DEVELOPMENT REVIEW BOARD
SUPPLEMENTAL SUBMITTAL

PROJECT NO. PR-2021-005597
Application No. SD-2022-00026

RE: PR-2021-005597/ SD-2022-00026 – PRELIMINARY PLAT

NAME: N:\Projects\W0007 Skansgard\W0007 0004 Skansgard Oxbow Center\3_CAD\W0007_4 Utility\Plan.dwg PLOT DATE: Feb 17, 2022 3:14pm

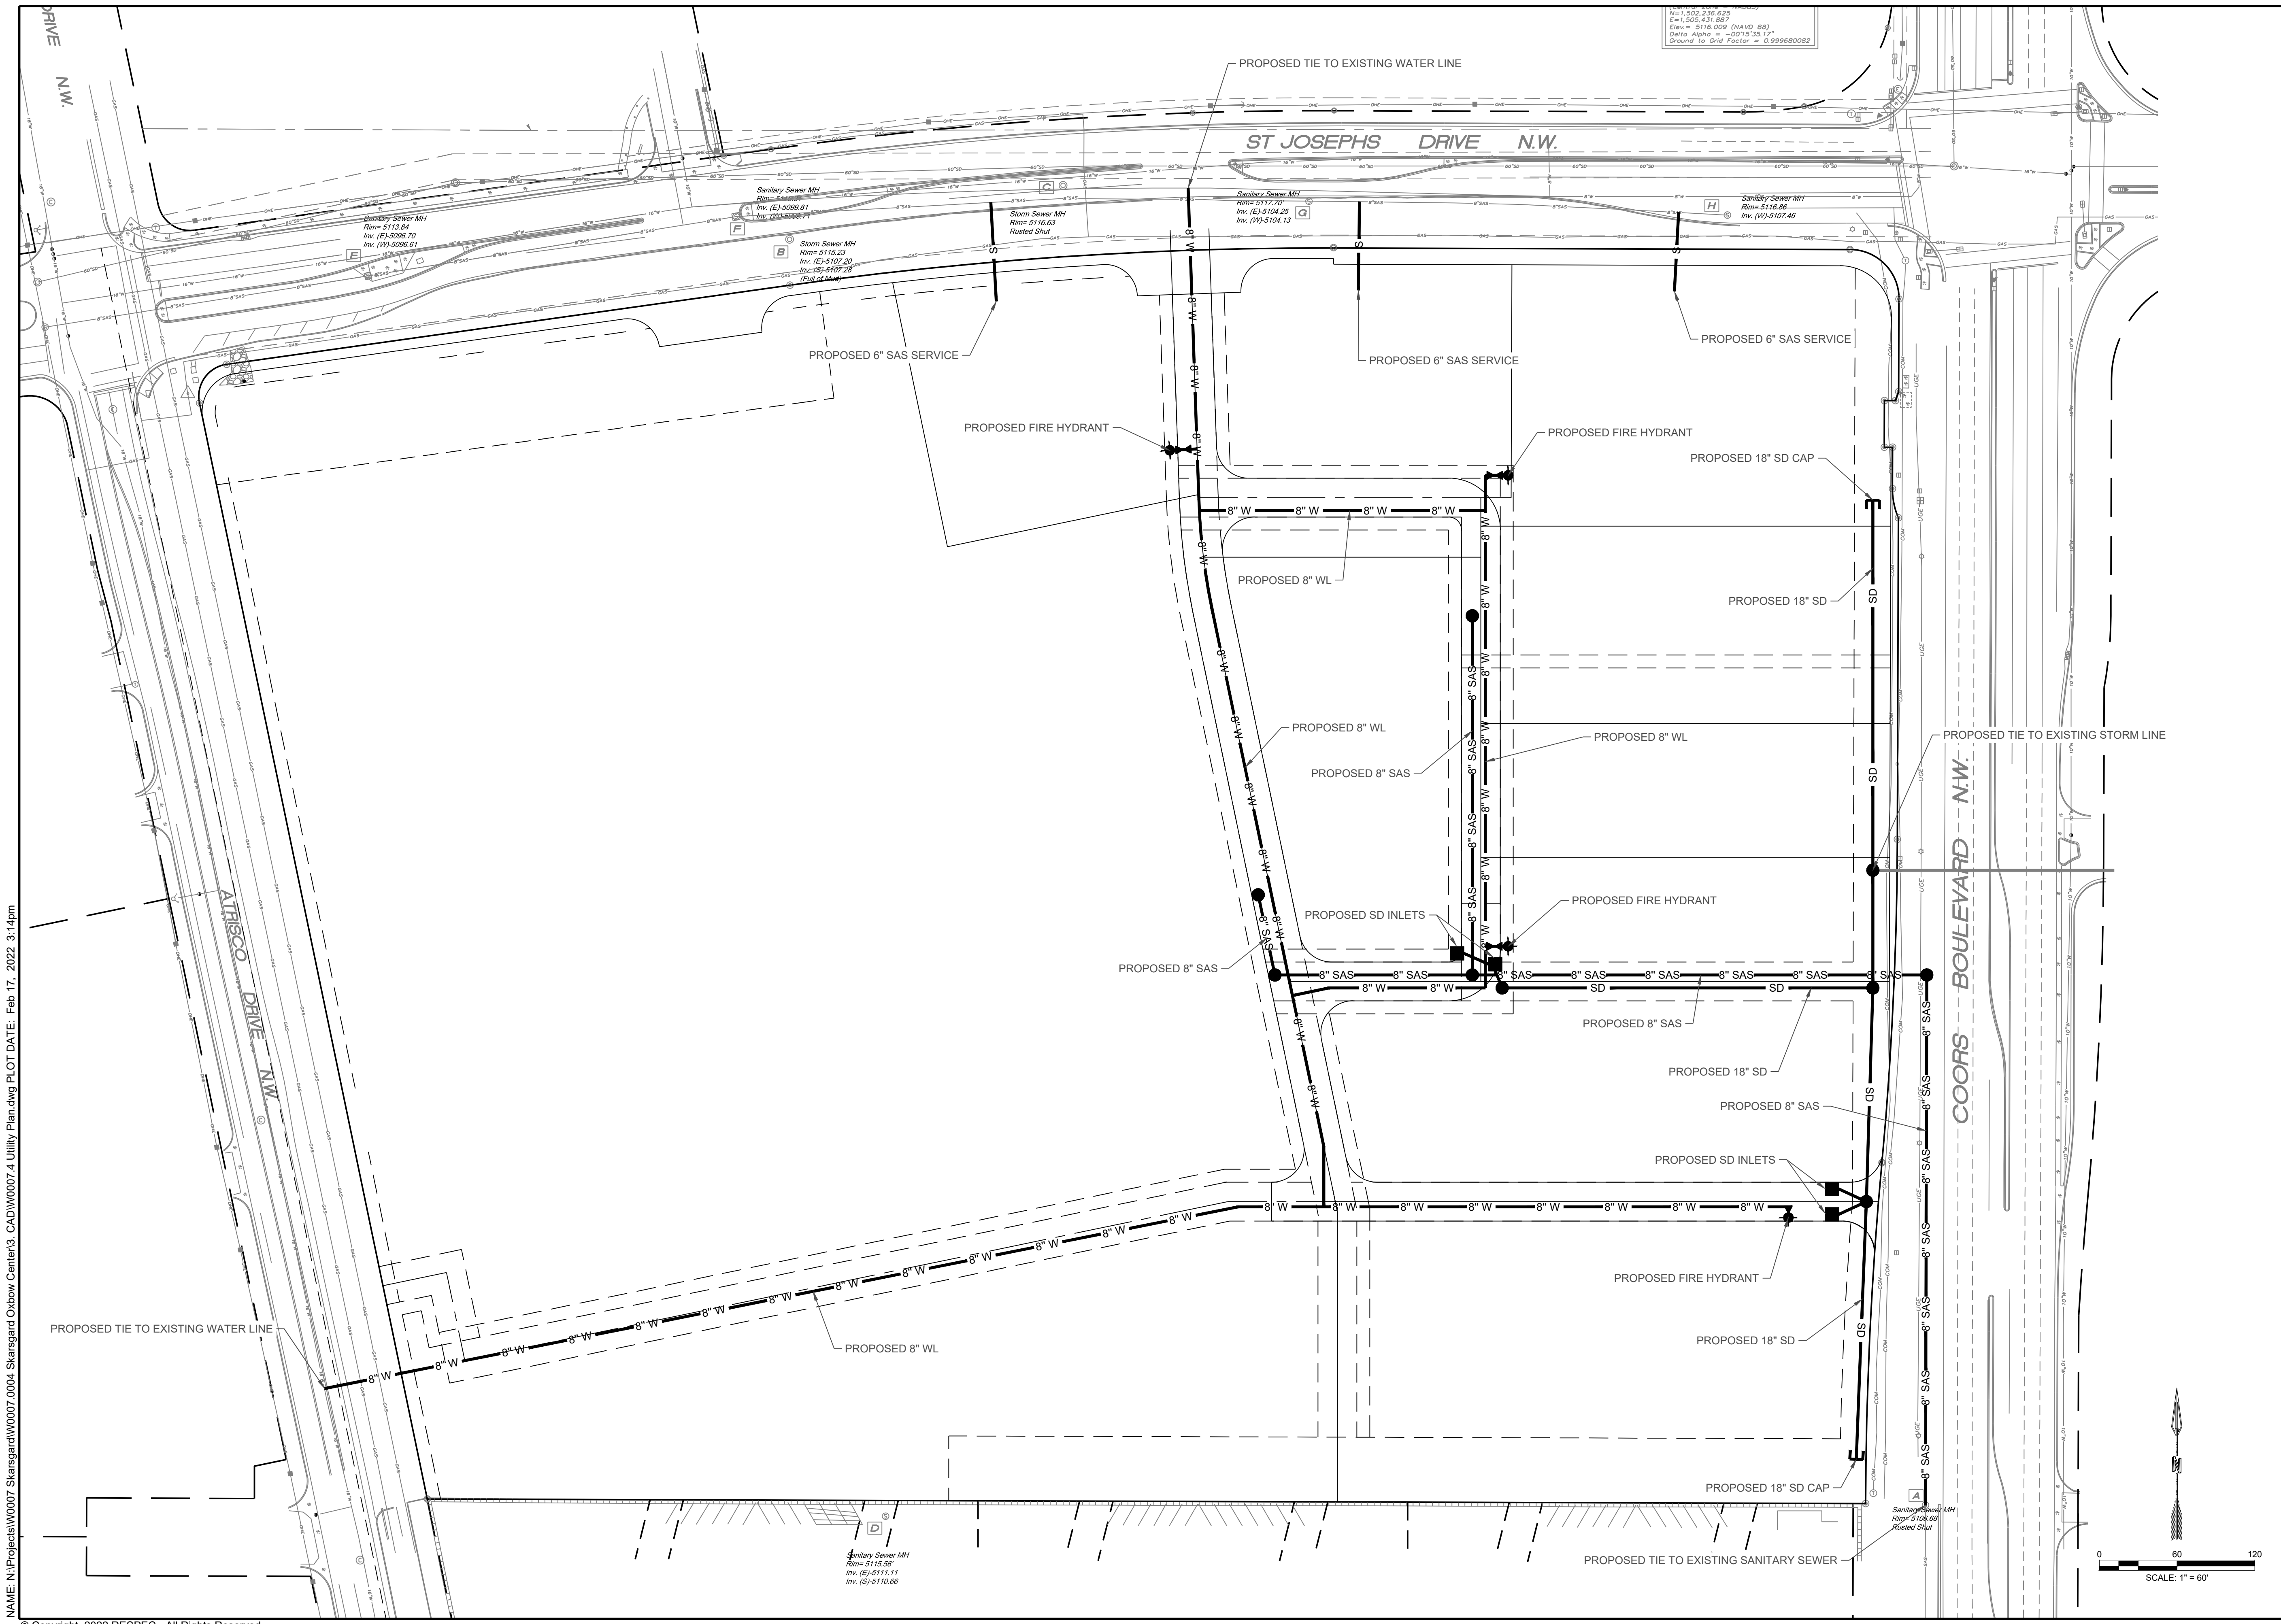
1. We need the updated Infrastructure List based on all comments associated with the list (Hydrology, Transportation, WUA)
2. The easement at the southwest corner needs to match the proposed waterline layout. If the waterline is proposed to make several turns, show that on the utility plan. Otherwise update the easement to match the straight waterline as shown on the utility plan.

Applicant Response – An updated infrastructure list has been added in this resubmittal to address all comments. The easement has been updated.
